**KIRKLEES METROPOLITAN COUNCIL
INVESTMENT & REGENERATION SERVICE**

Reference No:	2023/62/91239/W
Site Address:	31, Peel Street, Marsden, Huddersfield, HD7 6BW
Description:	Erection of single storey rear extension (within a Conservation Area)
Recommending Officer:	Luke Walstow

HOUSEHOLDER DELEGATED REPORT

Proposed rear elevation (1:100)

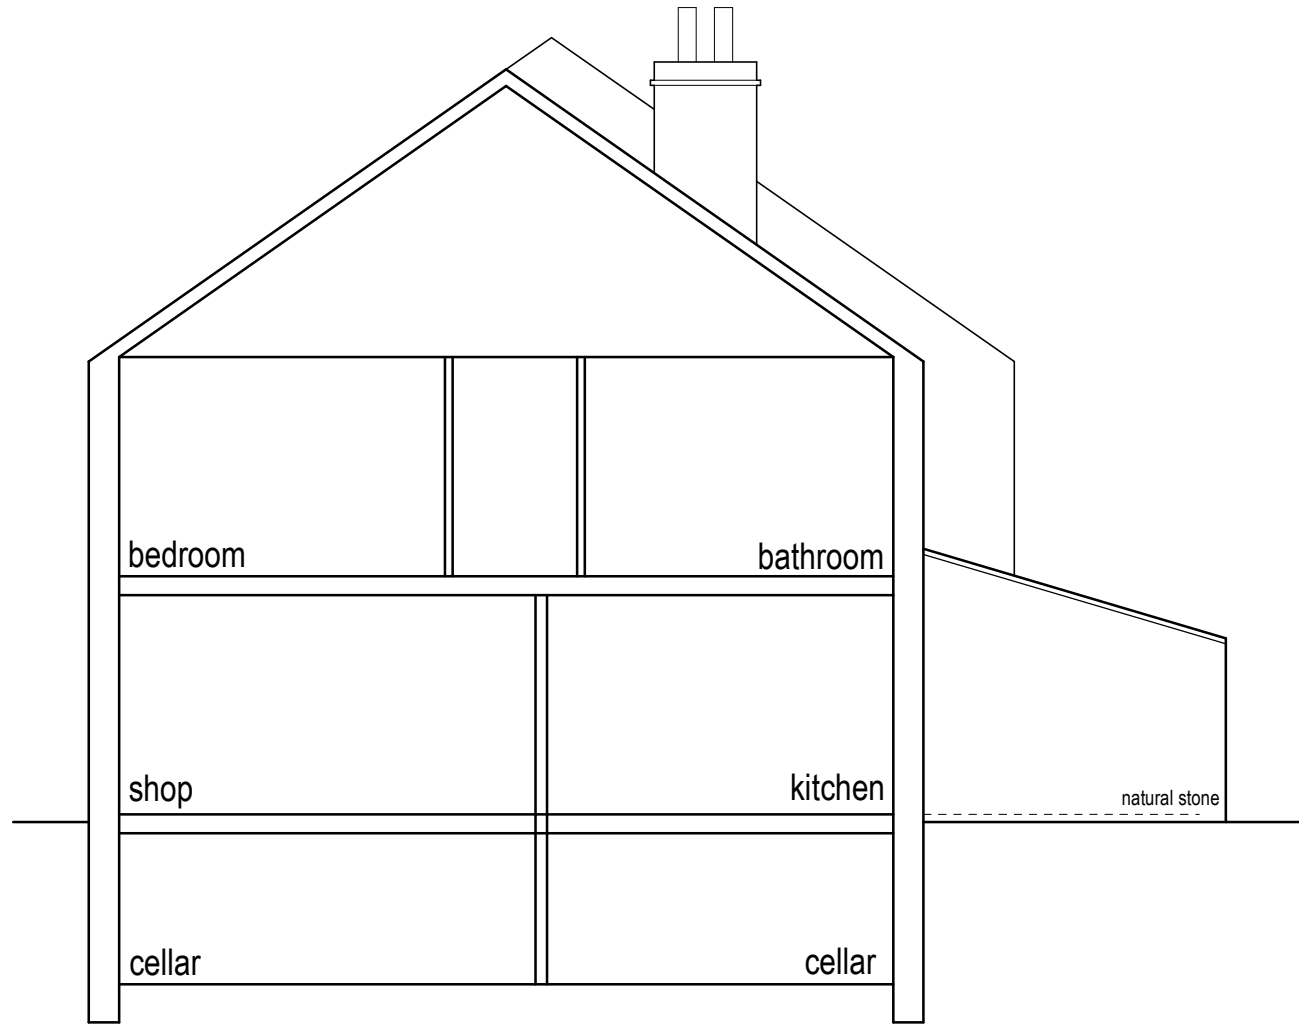
Not exceed 4 metres in height	The proposed height of the extension would be under 4 metres. (3.60m)	N/A
Not project out more than 3 metres from the rear wall of the original house for semi-detached and terraces houses or by 4 metres for detached properties	N/A	The host dwelling is a mixed use terraced property, meaning any rear extension should have a maximum projection of 3 metres. The proposal has a maximum projection of 4 metres which is the guidance for a detached dwelling. Whilst this is against guidance, due to the secluded location of the proposal and the relationship with adjacent property officers can acceptable the projection.
Where they exceed 3m in length the eaves height should generally not exceed 2.5 meters	Whilst the dwelling exceeds 3 metres in length, the eaves of the extension are stated to be 2.3 metres.	N/A
Retain a gap of at least 1 metre from a property boundary, such as a wall, fence or hedge	N/A	The proposed extension is proposed to be built directly on the boundary with the dwelling to the north. A site visit confirmed trees and hedges to line the boundary, acting as a natural screen. A large stone wall acts as a screen on the other side of the extension. Due to these screens, the proposal is considered to be acceptable in its relation to the property boundary.

Chapter 12 of the NPPF	projection, height and width all being classed as subservient when being compared against the host dwelling and surrounding development	
Facing materials and detailing	- KDP 9 of the SPD - Policy LP24 Design (d) (iii) of the KLP - Chapter 12 of the NPPF	The external walls of the extension would be constructed from stone which matches the host dwelling. The roof tiles proposed also harmonise with the existing dwelling. By using materials which match the existing dwelling, the proposal is considered to have good quality design, thus being acceptable.	✓
Roof style	- KDP 1 and 2 of the SPD - Policy LP24 Design (a), (c) and (d) of the KLP - Chapter 12 of the NPPF	The roof style for the extension would be a lean to roof which would sit against the host dwelling. Natural blue slate is proposed for the roof which would match the existing dwelling. 3 rooflights are proposed within the roof to provide natural light into the extension. The proposed detail of the roof is considered to be acceptable.	✓

Window proportions	- KDP 1 and 2 of the SPD - Policy LP24 Design (a), (c) and (d) of the KLP - Chapter 12 of the NPPF	Two windows are proposed within the rear elevation of the extension. These windows are of similar design to the host dwelling. 3 rooflights are proposed within the extension roof. The windows are deemed to be an acceptable size and would not create potential residential amenity issues.	✓
